Rezoning Transportation Analysis

Petition Number: 2023-091

From: Jake Carpenter, PE

Date	Description
9-28-23	First Review (NK)
10-26-23	Second Review (JP)

STREET SECTIONS

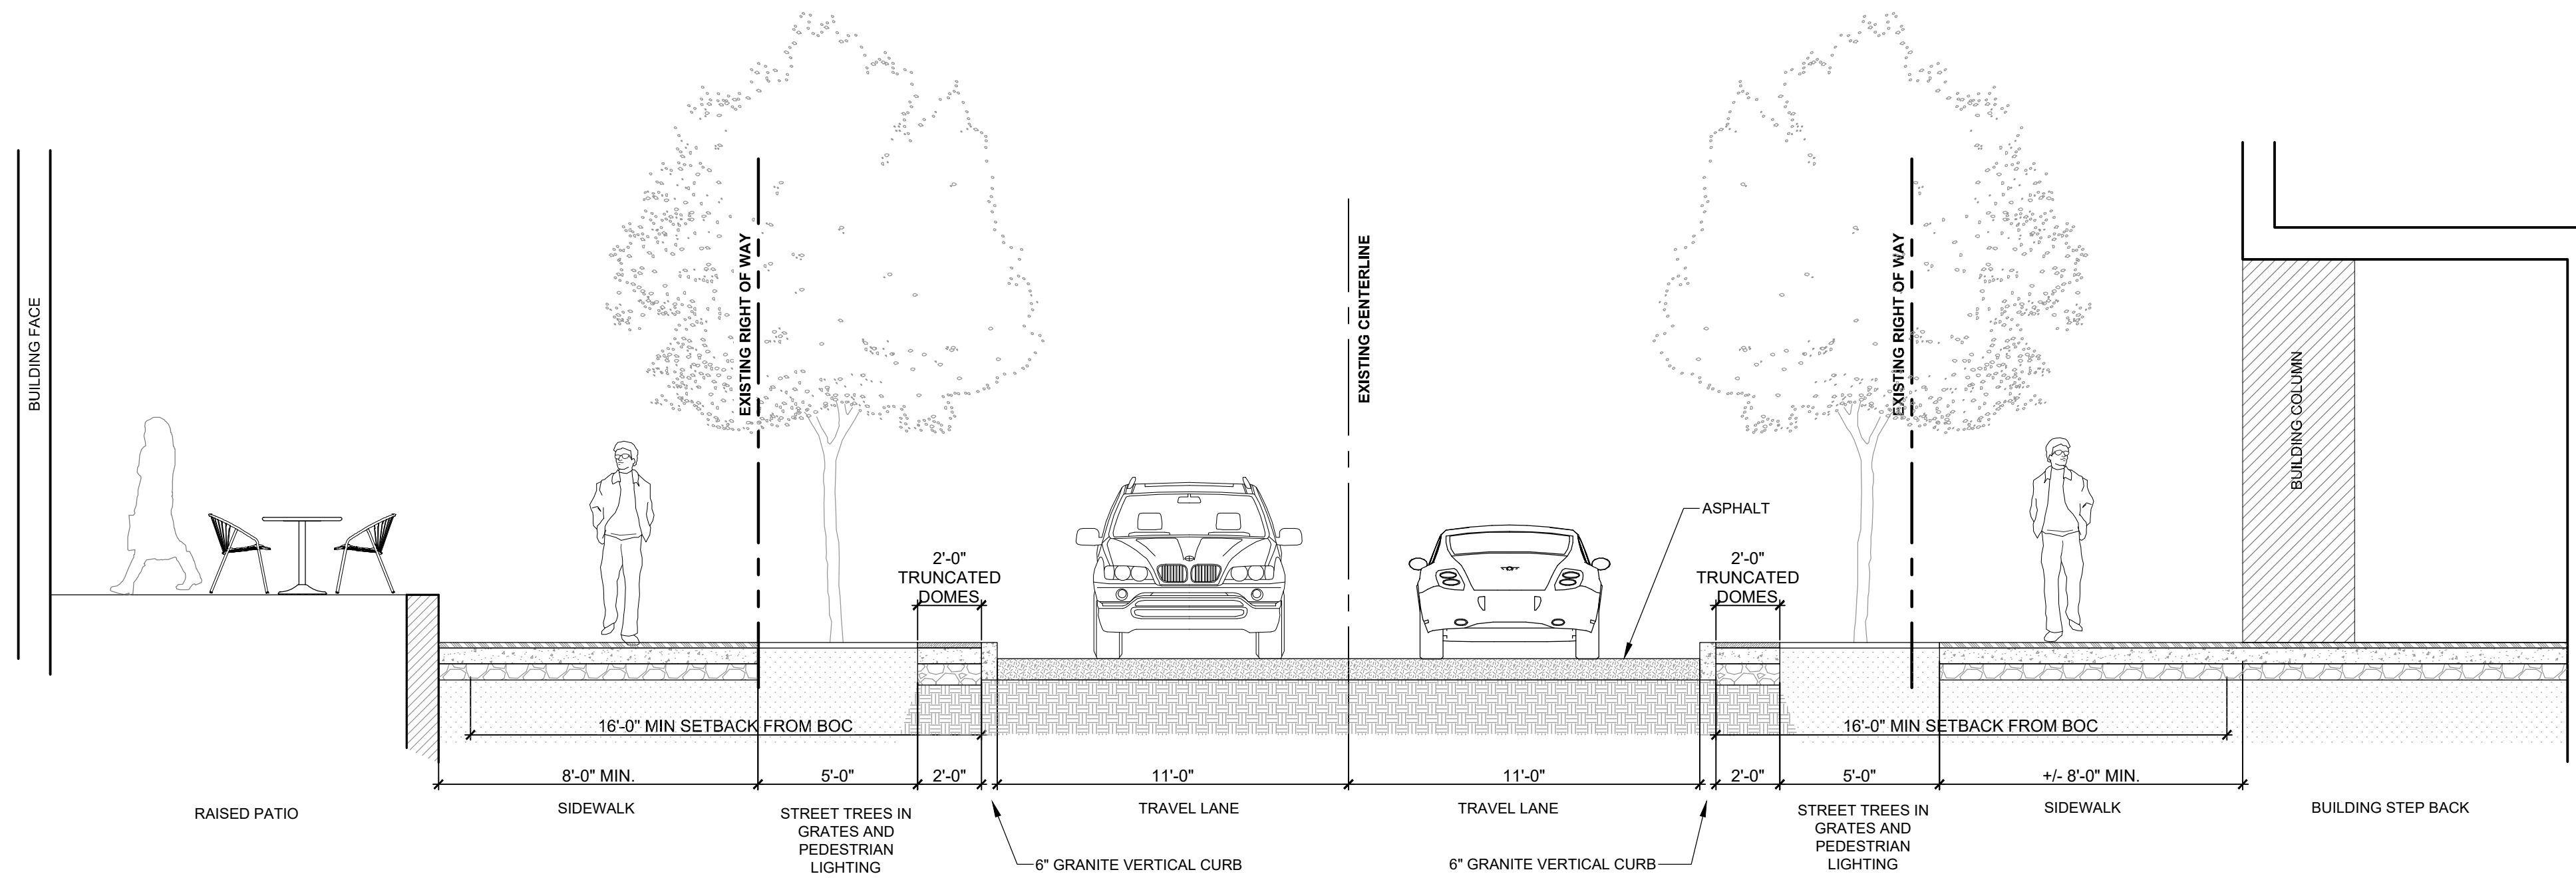
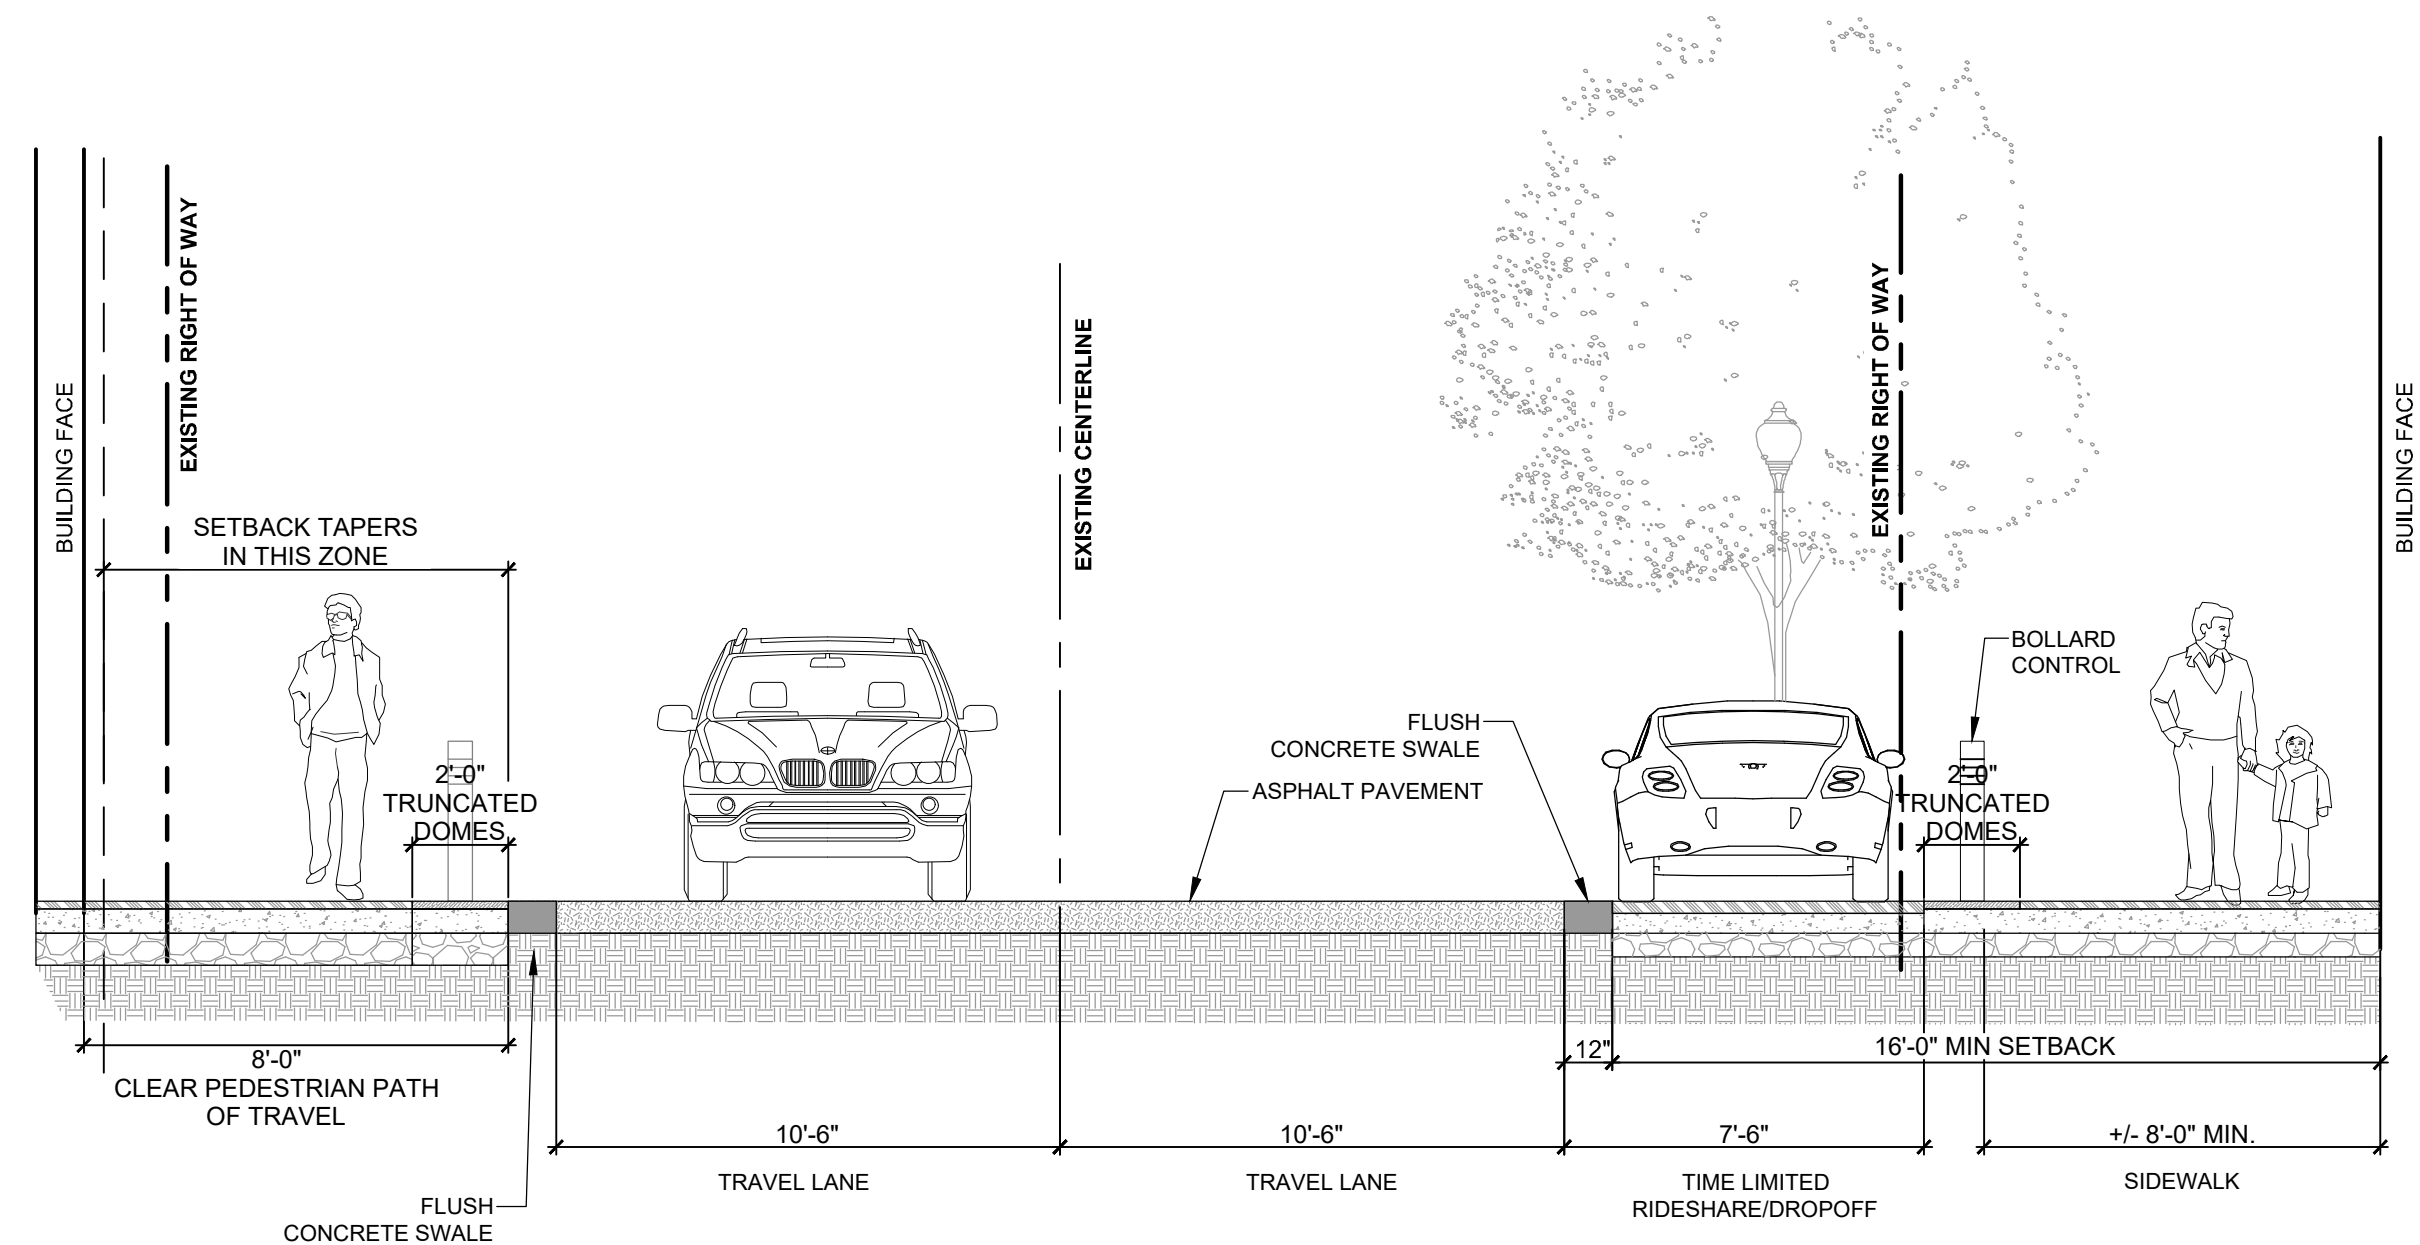
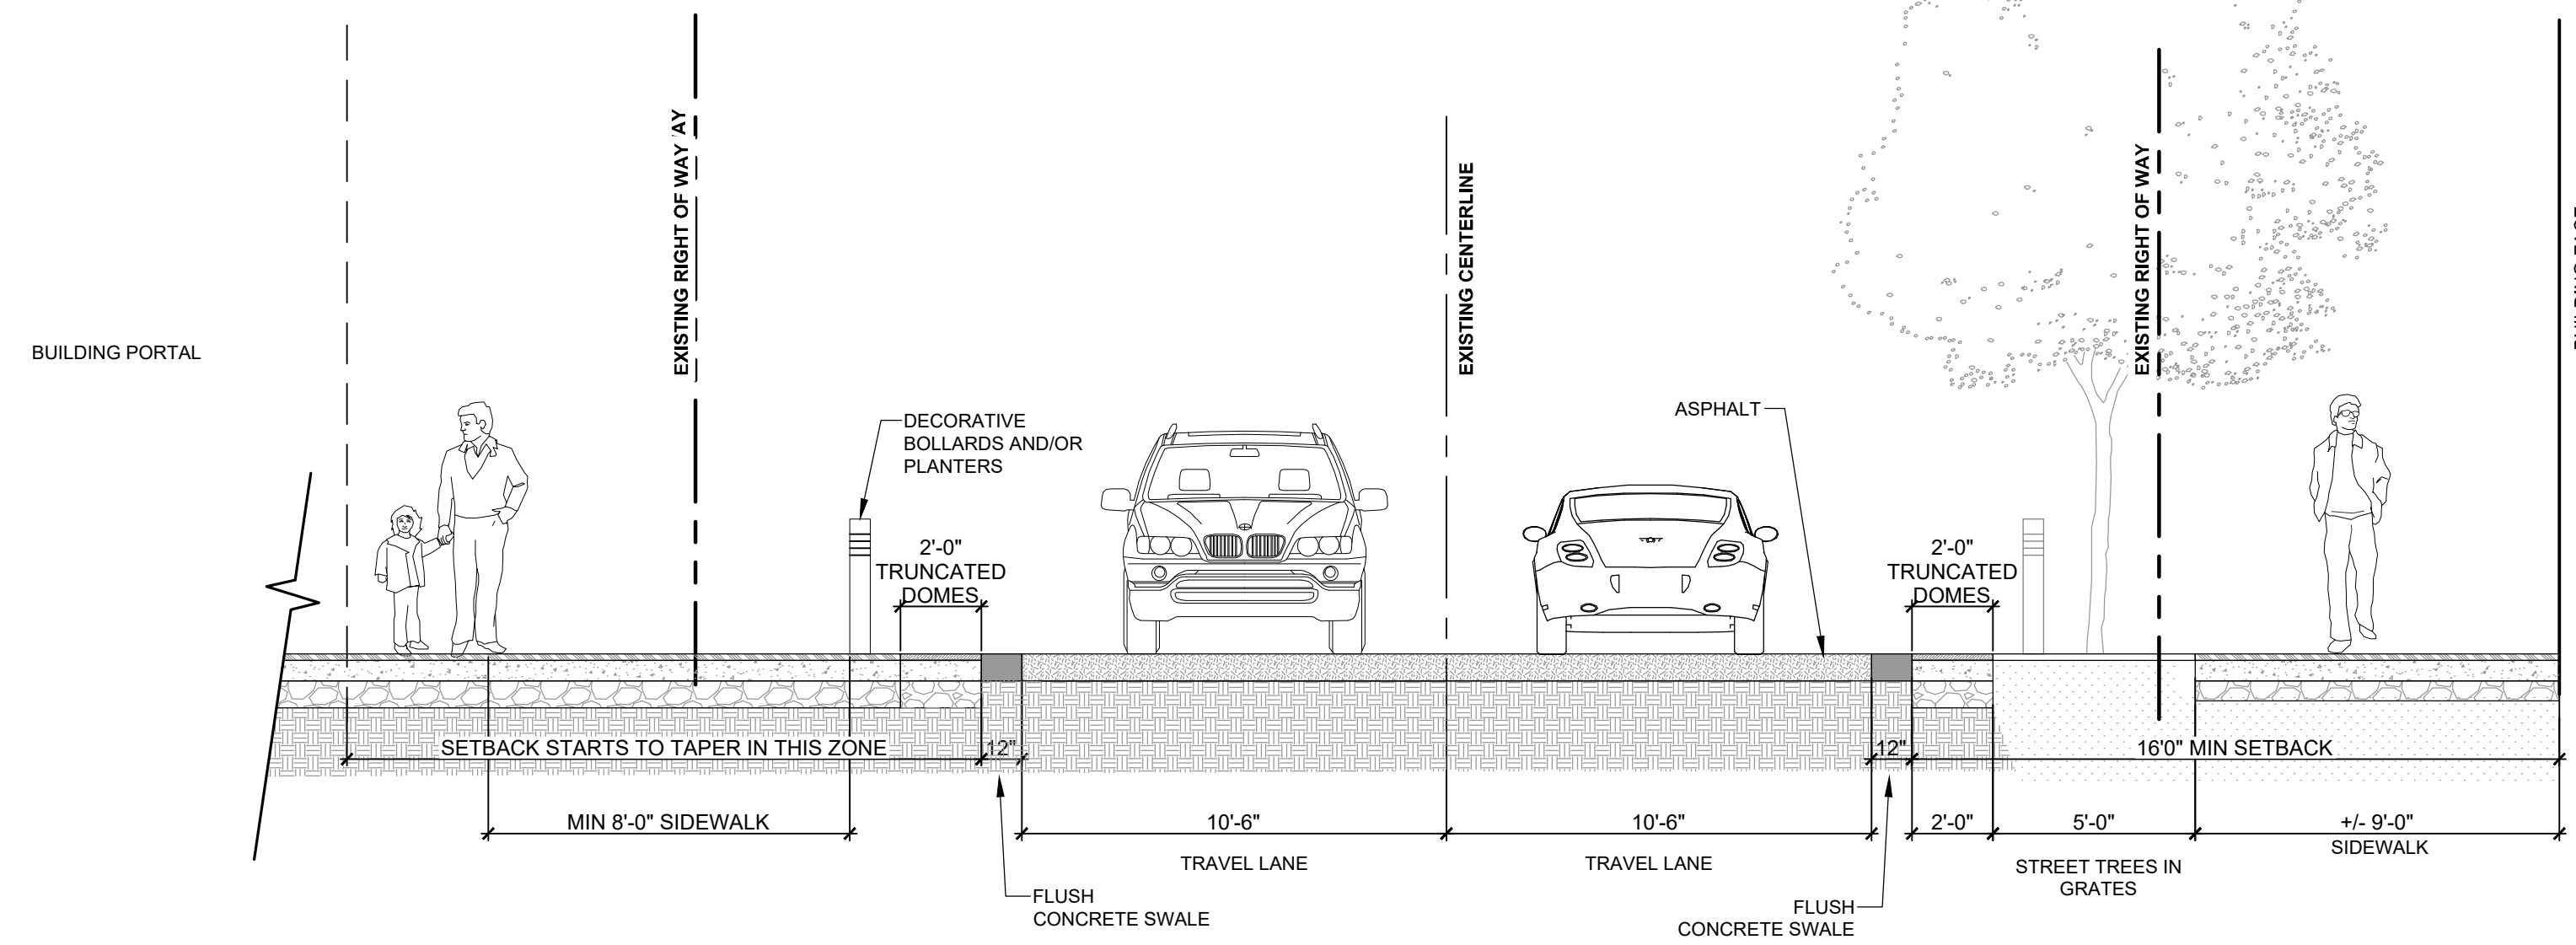
- ~~4. Revise site plan and conditional note(s) to commit to construct bicycle facilities by installing a 10' multi-use path along East 6th street, North College Street, and East 7th Street. in accordance with the council-adopted Charlotte Streets Map. Multi-use paths maintained by the City shall meet ADA/PROWAG requirements.~~

- ~~5. Revise site plan and conditional note(s) to commit to construct bicycle facilities by installing a 12' multi-use path along North Tryon Street in accordance with the council-adopted Charlotte Streets Map. Multi-use paths maintained by the City shall meet ADA/PROWAG requirements.~~
